ENLARGED SITE PLAN

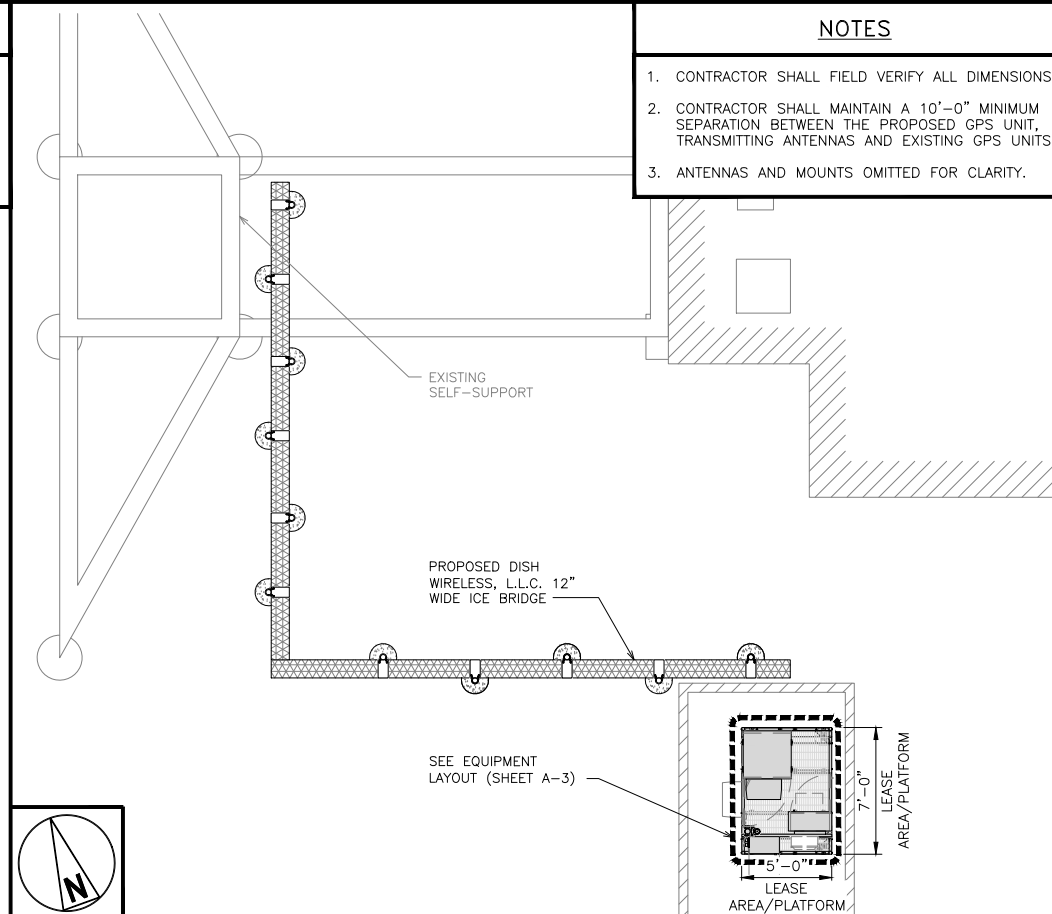
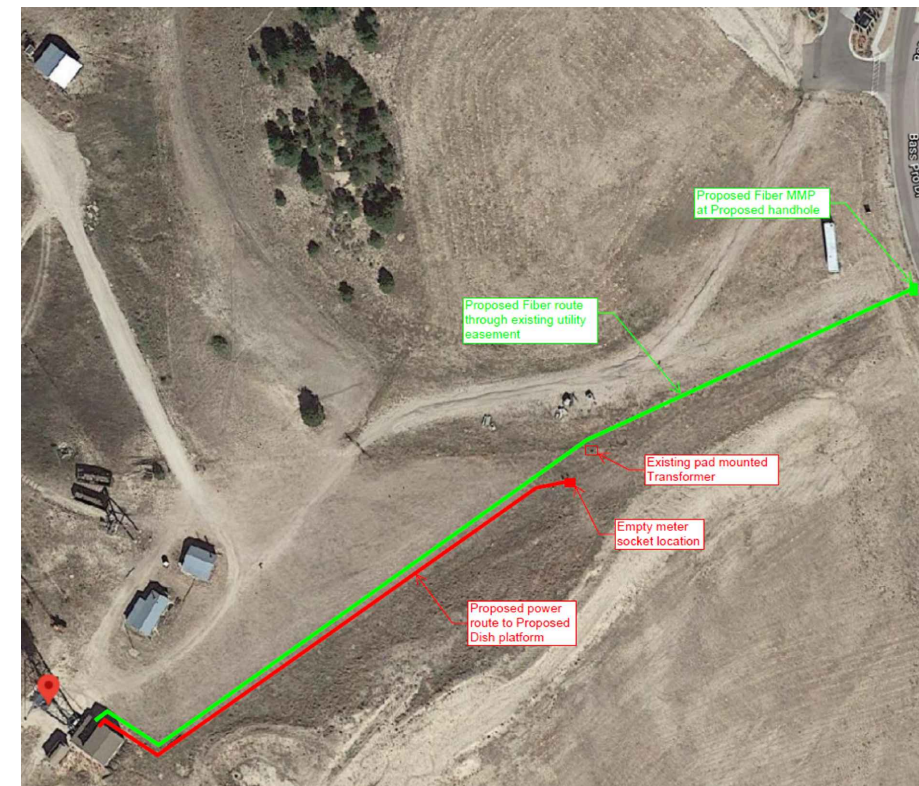
Please resubmit the site plan drawing. The drawing appears cut off.

please resubmit the site plan drawing. Once resubmitted there may be additional comments.
